WEST SUSSEX COUNTY COUNCIL CONSULTATION

TO:	Arun District Council FAO: Anita Gardner
FROM:	WSCC - Highways Authority
DATE:	9 September 2020
LOCATION:	Rustington Golf Centre Golfers Lane Littlehampton BN16 4NB
SUBJECT:	A/131/20/PL New outdoor climbing area, kiosk, briefing room & net gain of 31 No. car parking spaces. This site is in CIL Zone 3 (Zero Rated) as 'other development'.
DATE OF SITE VISIT:	n/a
RECOMMENDATION:	Advice
S106 CONTRIBUTION TOTAL:	n/a

Title **Block Plan**

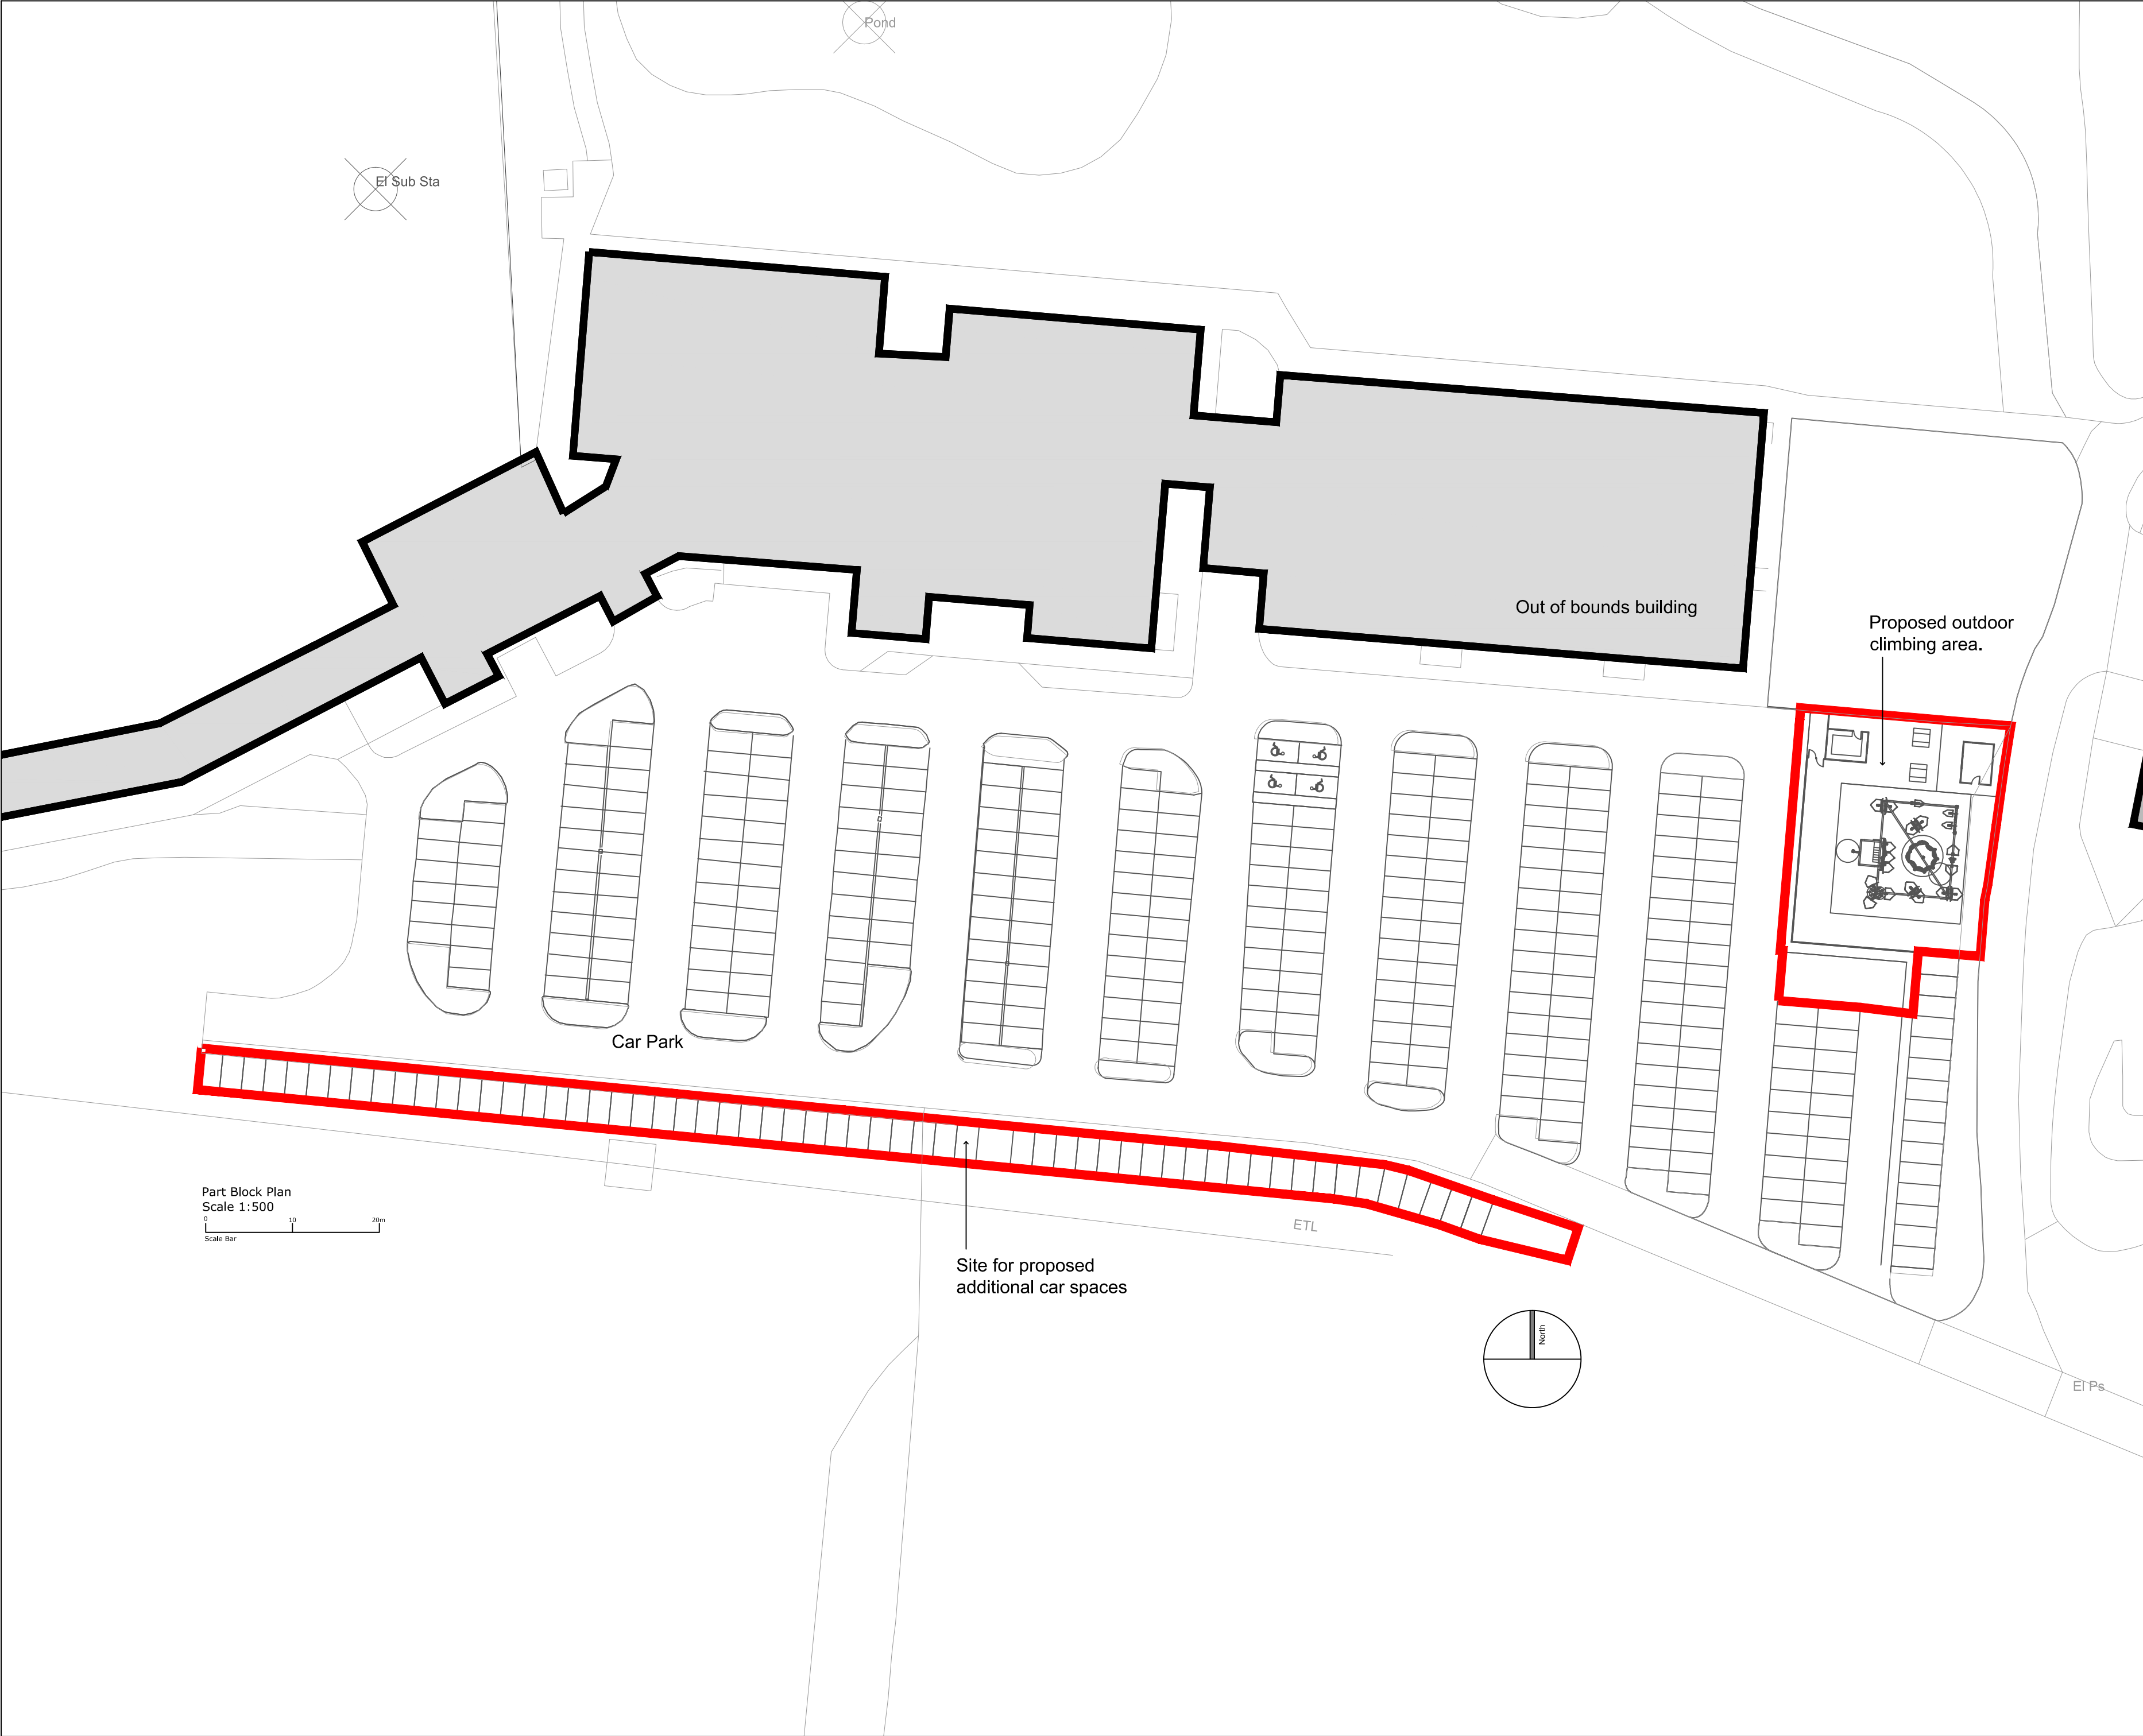
The proposals are to create a new outdoor climbing area close to the existing clip and climb facility. The proposals will result in a loss of 27 existing car parking spaces. To supplement this the applicant proposes to create 58 new spaces to the southern edge of the existing car park with a net gain of 31 spaces. The additional spaces are all positioned to allow a two way traffic flow through the existing car park. The LHA would be satisfied with the arrangement, the LHA should advise that the spaces are laid out in line with the national parameters of 2.4 by 4.8 metres.

No part of the development shall be first occupied until the car parking spaces have been constructed in accordance with plans and details to be submitted to and approved in

writing by the Local Planning Authority. These spaces shall thereafter be retained at all times for their designated use.
